From: BCTAdmin@thameswater.co.uk
To: [Planning](#)
Subject: 3rd Party Planning Application - 6/2019/1788/COND
Date: 12 August 2019 09:38:00

Our DTS Ref: 26322
Your Ref: 6/2019/1788/COND

Re: FORMER SHREDDED WHEAT FACTORY, BRIDGE ROAD, WELWYN GARDEN CITY,
HERTFORDSHIRE, AL8 6UN

Thank you for consulting Thames Water for the discharge of matters relating to SURFACE WATER. Thames Water are unable to support the discharge of this condition for the reasons outlined below.

PROPOSED DRAINAGE LAYOUT (PHASE 1)

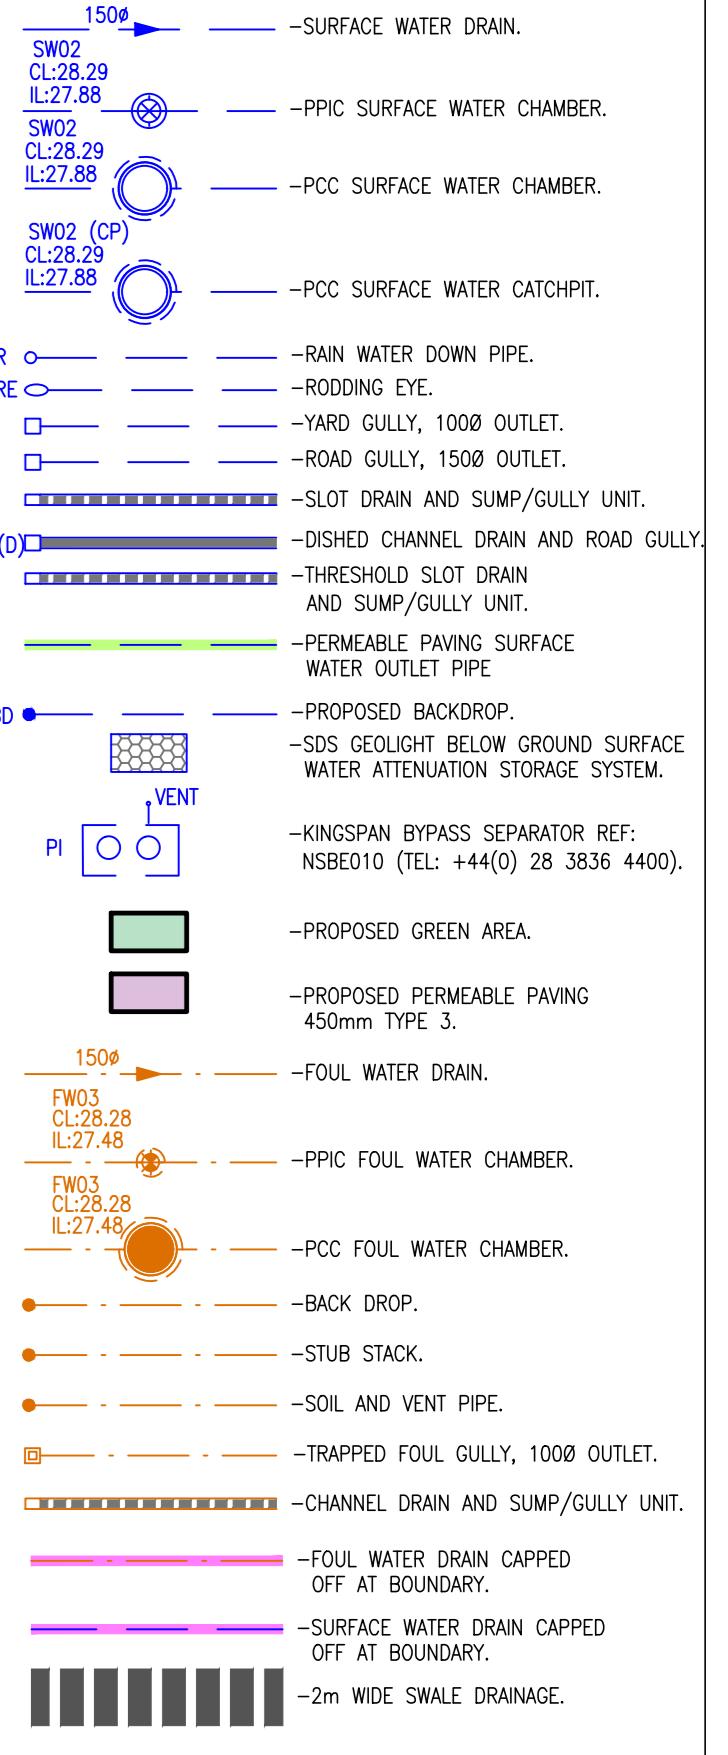
The strategy lacks detail only calculations which don't articulate the intended flows etc. Give a brief description of volumes, discharge rates say 1:1, 1:10, 1:30 and 1:100. Also show and give capacity of any attenuation.
